**TOWN AND COUNTRY PLANNING ACT 1990  
APPLICATION Ref. 19/01047/OUT BANKSIDE PHASE 2  
OUTLINE PLANNING APPLICATION FOR A RESIDENTIAL DEVELOPMENT OF UP TO 825 DWELLINGS;  
GREEN INFRASTRUCTURE INCLUDING FORMAL (PLAYING FIELDS WITH CHANGING ROOMS,  
ALLOTMENTS) AND INFORMAL OPEN SPACE; LANDSCAPING AND ASSOCIATED INFRASTRUCTURE  
INCLUDING A BALANCING POND; ON LAND OFF THE A4260, WITH ACCESS OFF THE EXISTING  
LONGFORD PARK ACCESS OFF THE A4260 (OXFORD ROAD), AND A NEW ACCESS OFF THE A4260  
(BANBURY ROAD). ALL MATTERS OF DETAIL RESERVED, SAVE FOR ACCESS'**

I welcome your considerations regards a proposed amendment requested by the Local Highway Authority (LHA) for the site access (from Banbury Road) and internal spine road. The LHA seeks the addition of a 3m cycleway following the publication of LTN 1/20. I here set out a brief background below.

- Dwg no: 10994-10-SK\_018 Rev C Planning Layout
- Dwg no: 6394-P-01 rev BC - Parameters plan

Status		Status Date
Approval		DEC 2023
Drawn	Checked	Date
SB	MT	21.12.23
Scale	Number	Rev
1:500	10994-10-SK_018	C

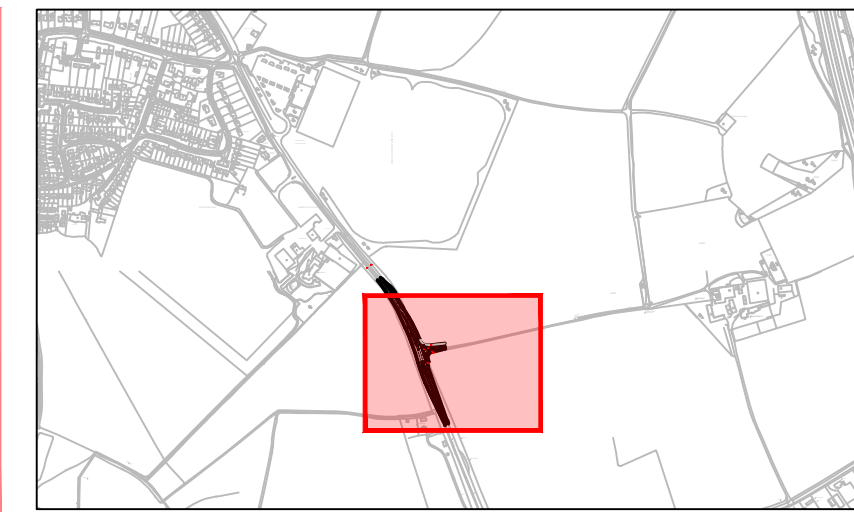
1.3. The site access, off Banbury Road, is detailed within the outline application. The details of the internal spine road will be subject to further Reserved Matters submissions. To facilitate the 3m cycle path, the following plans included in the outline application, subject of the resolution to grant planning permission, have been amended. The amended plans are set down below, and attached to this letter.

1.4. The addition of the cycle path has resulted in a reduction of the number of dwellings by five due to a slightly reduced developable area. Accordingly, it is proposed the description of development is amended to:
